BULLETIN No. 3

Date: May 29, 2012
To: **Allied Cook**
RE: **TSL Building - Showroom and Service Bay Additions
Portland, Maine**

JHN #: 2008-279.0

A502

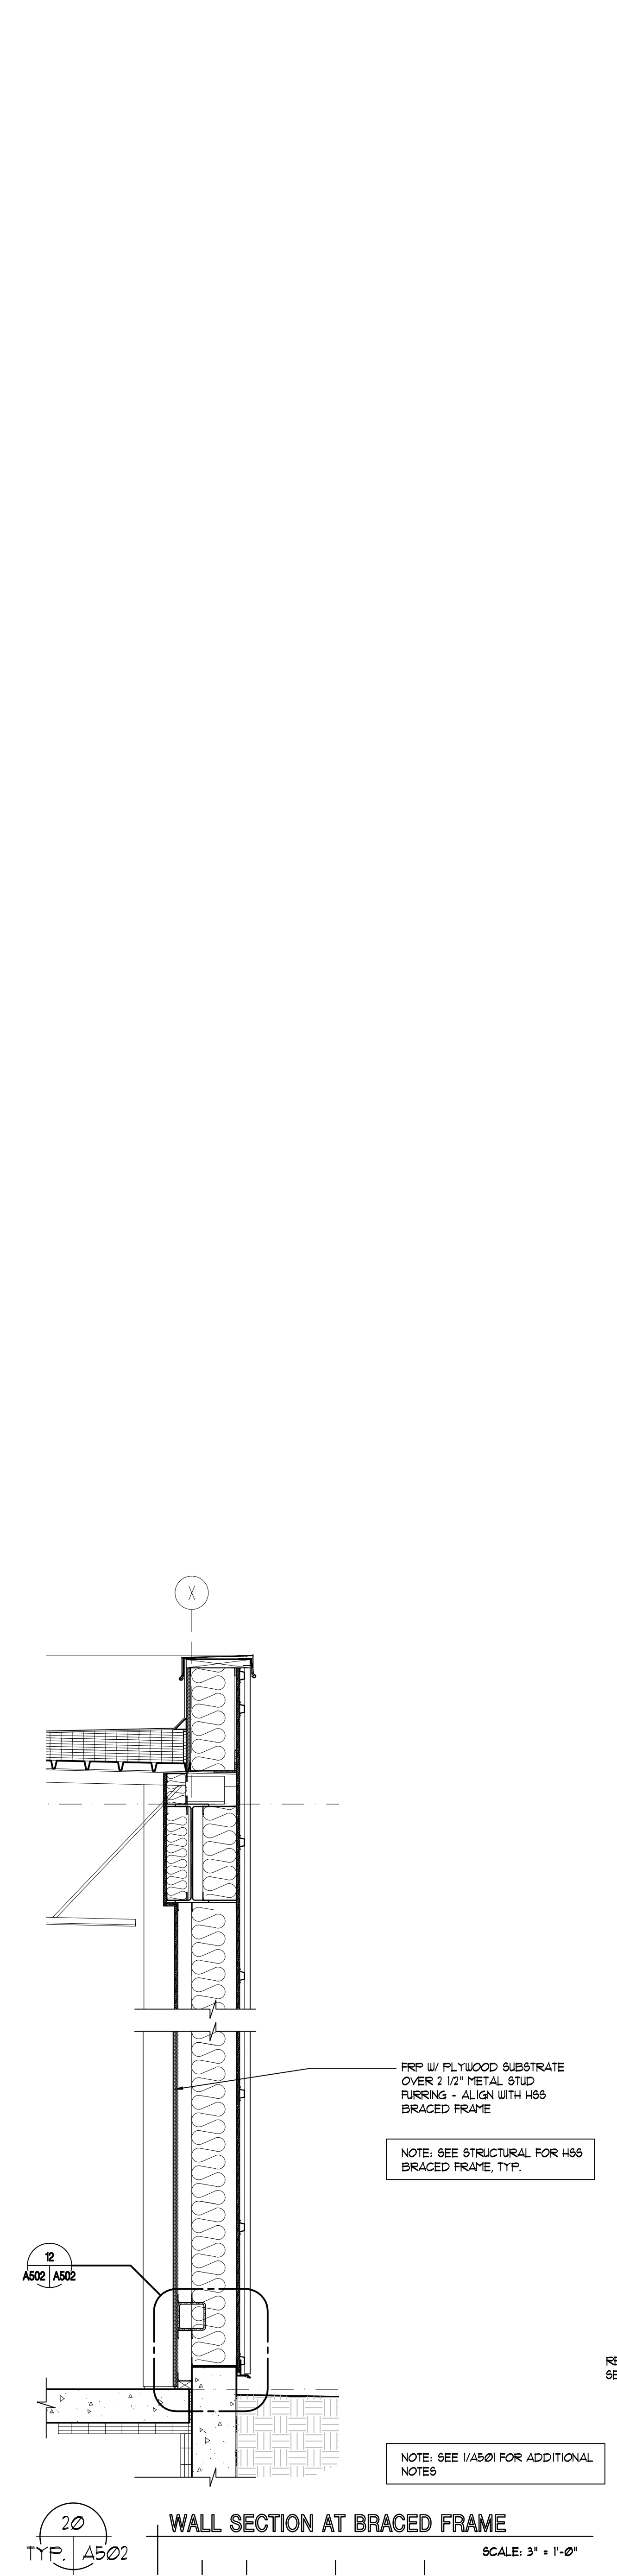
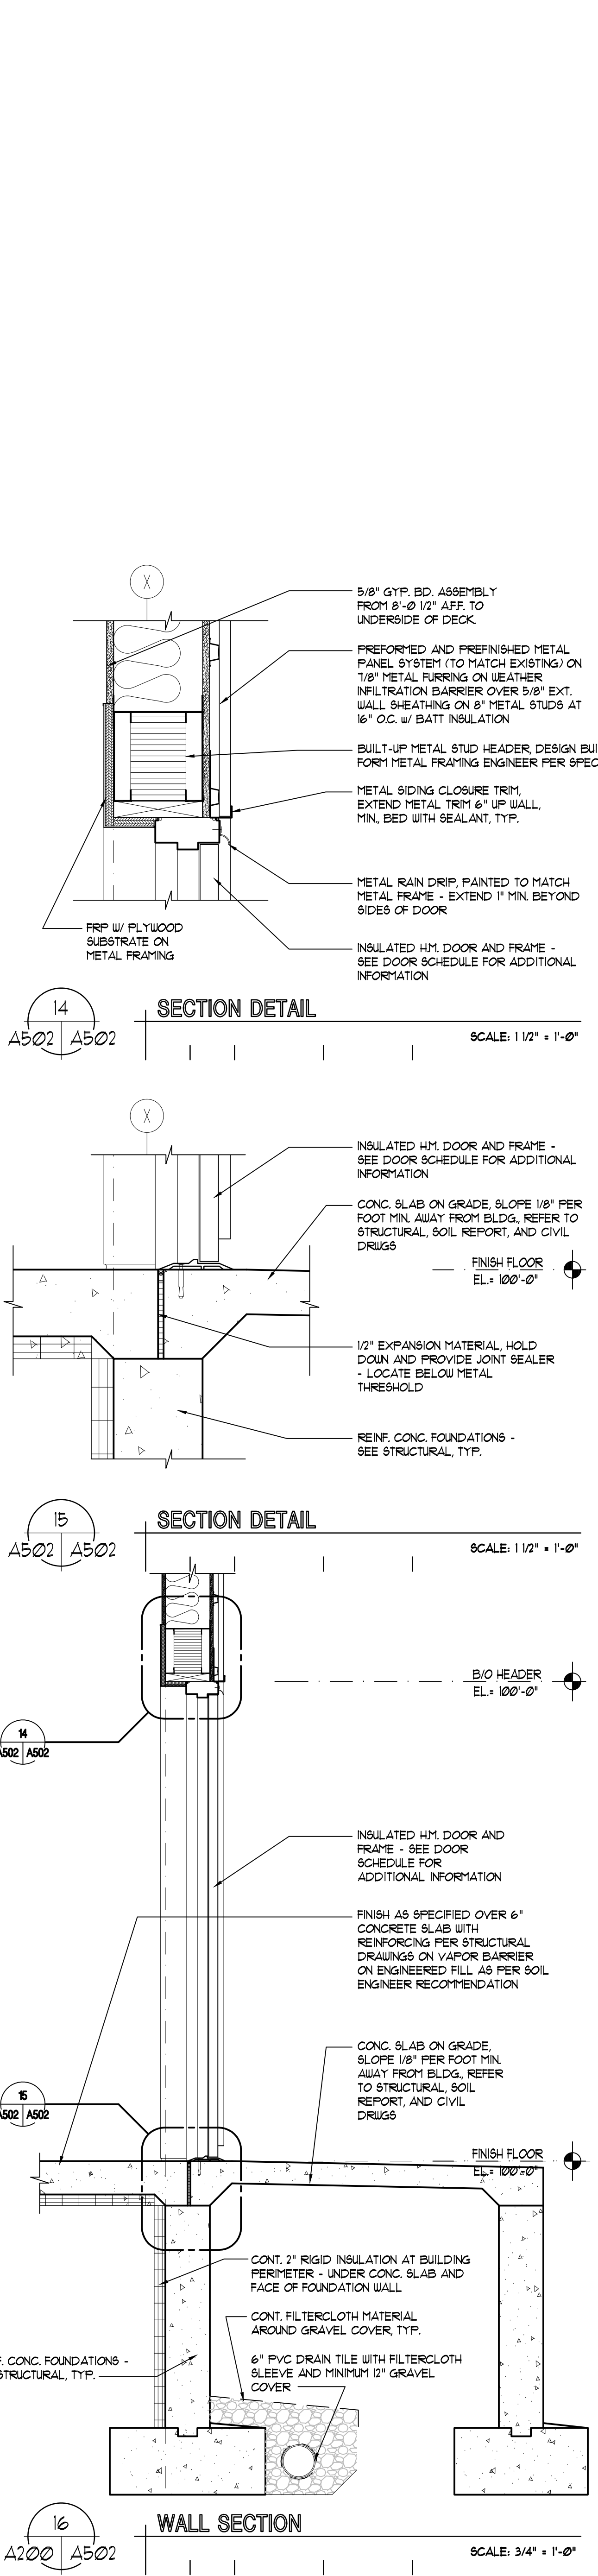
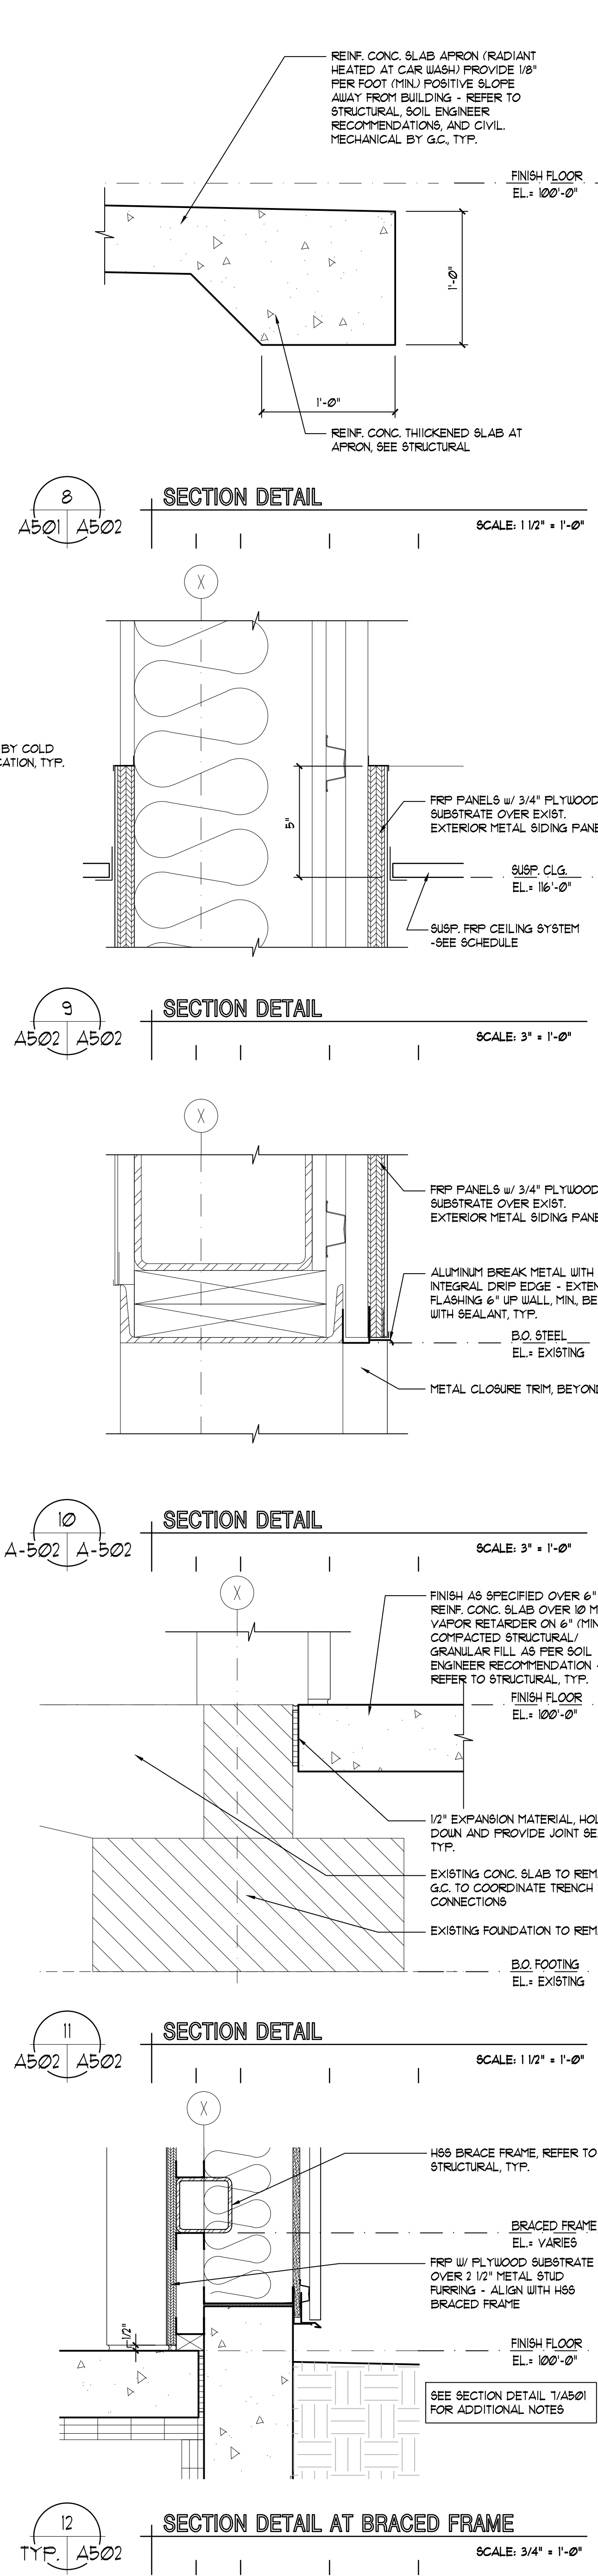
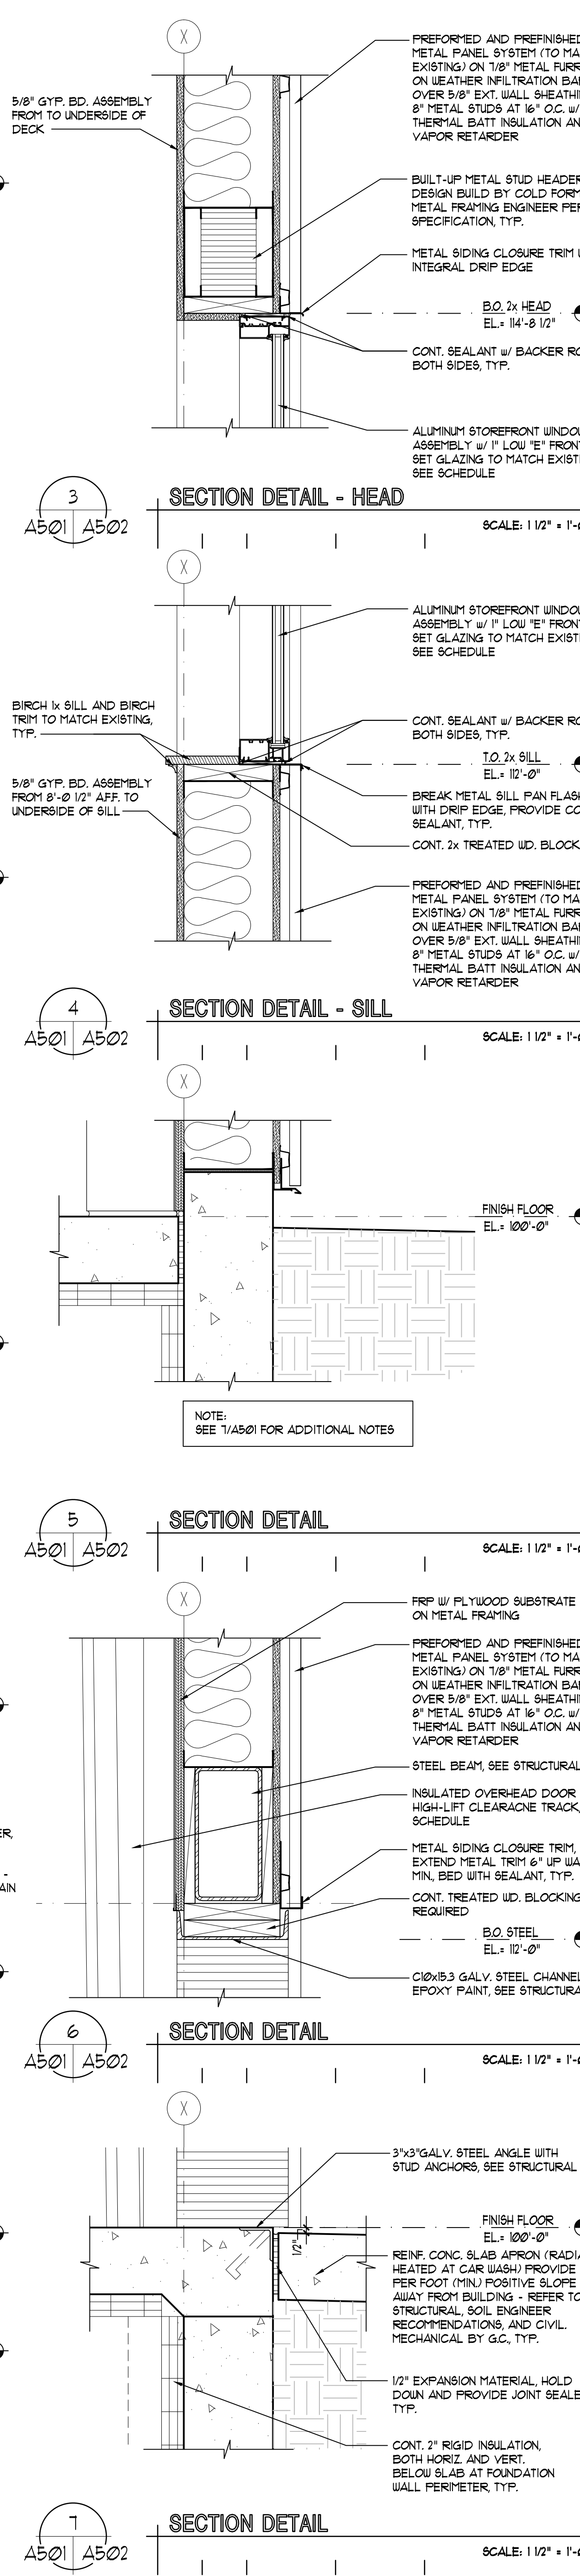
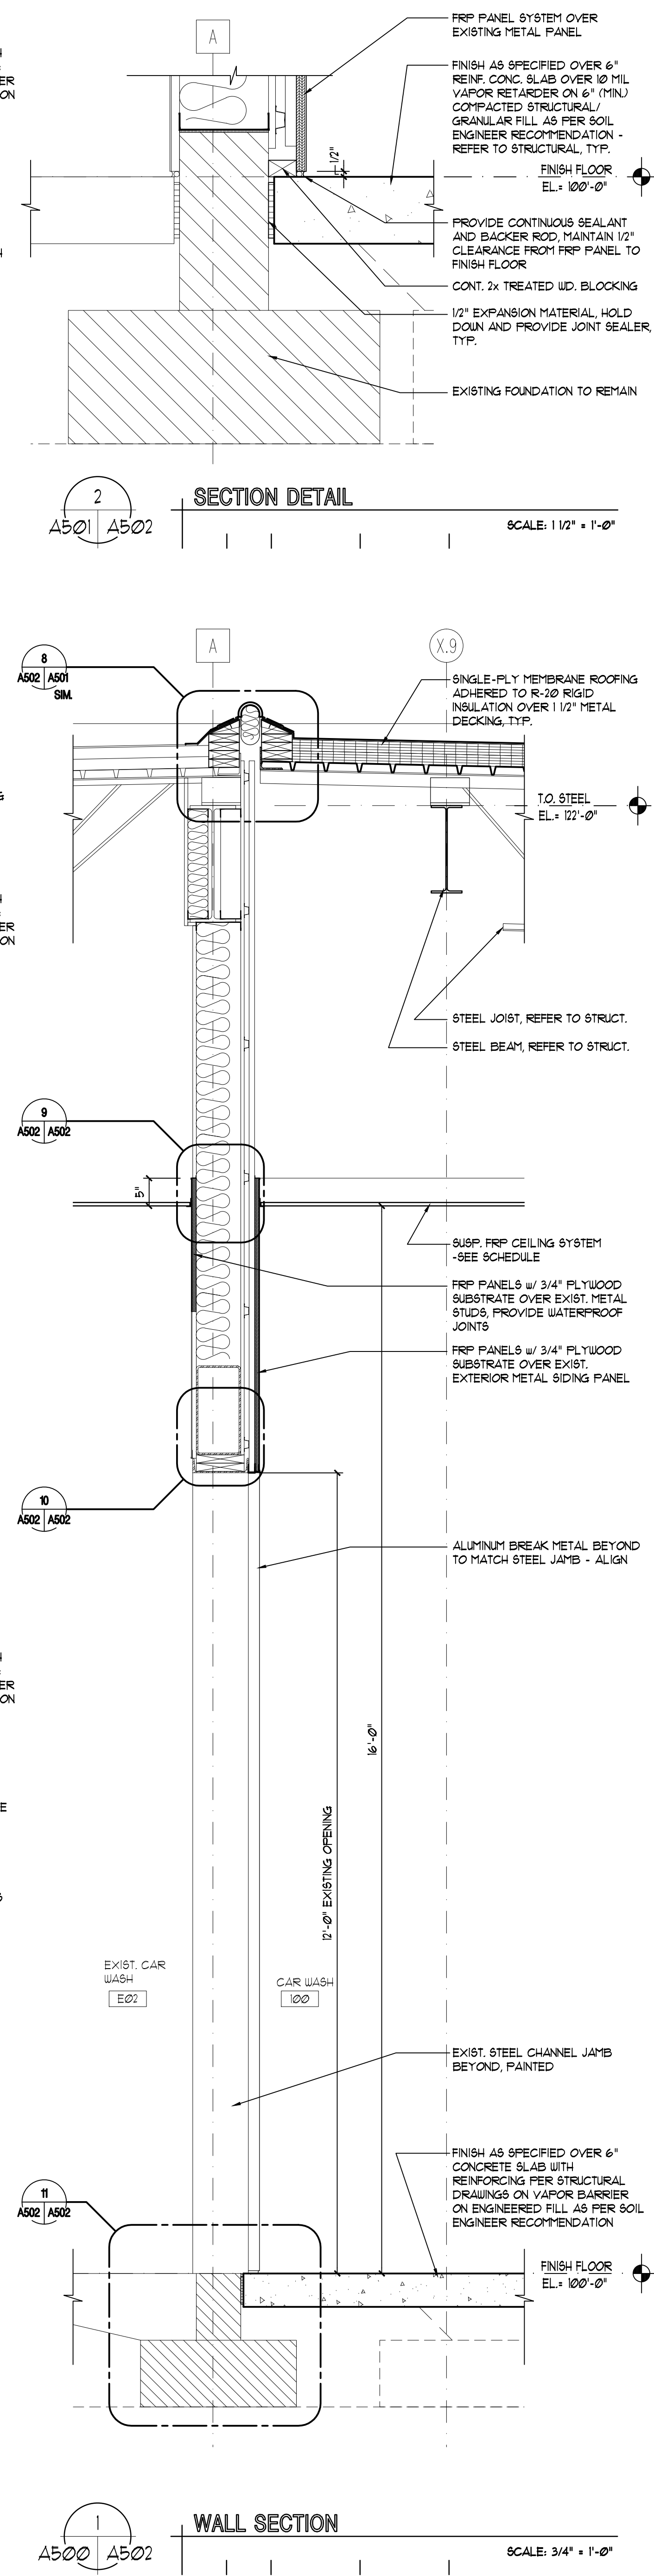
Item 2.1 Refer to sheets A101, A502

- *Indicated owner supplied and vendor installed equipment on floor plan.*

FOUNDATION PLAN
 AND GENERAL
 NOTES

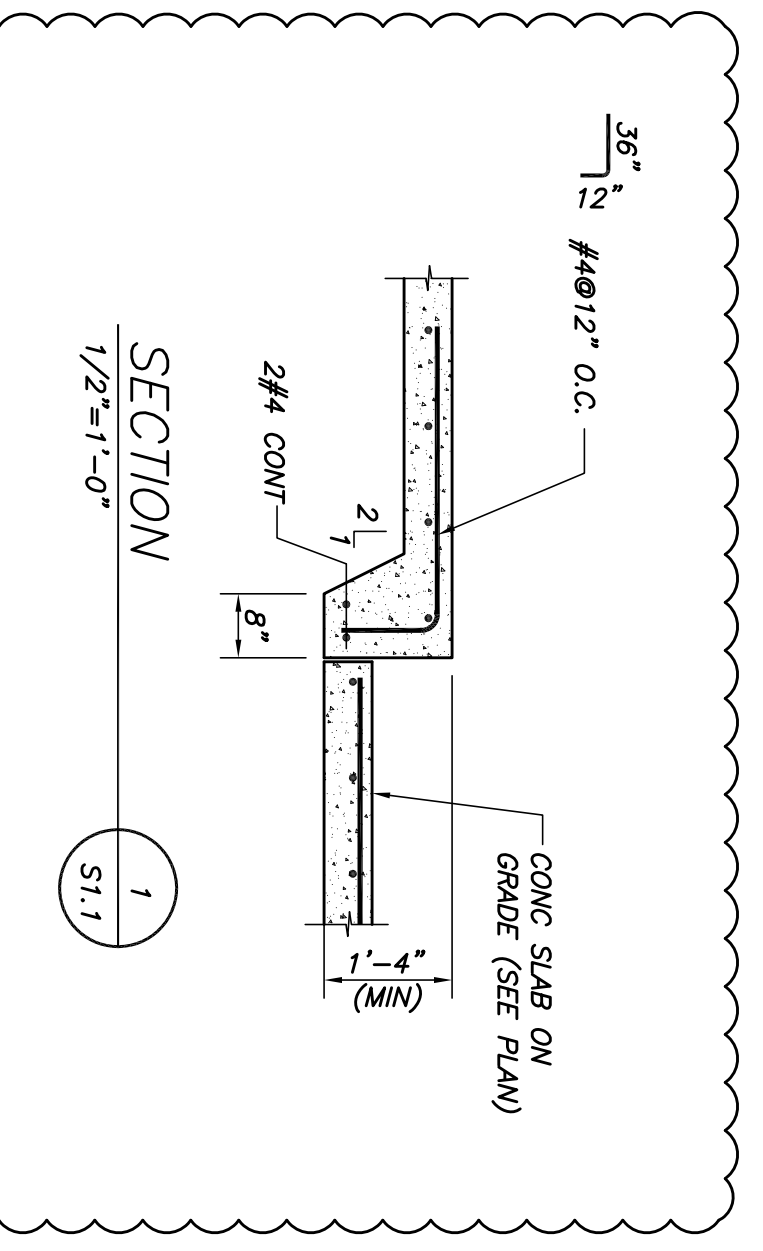
Item 3.1 Refer to sketch S1.1 ad S1.2

- *Revised structure as required for owner supplied, vendor installed equipment.*
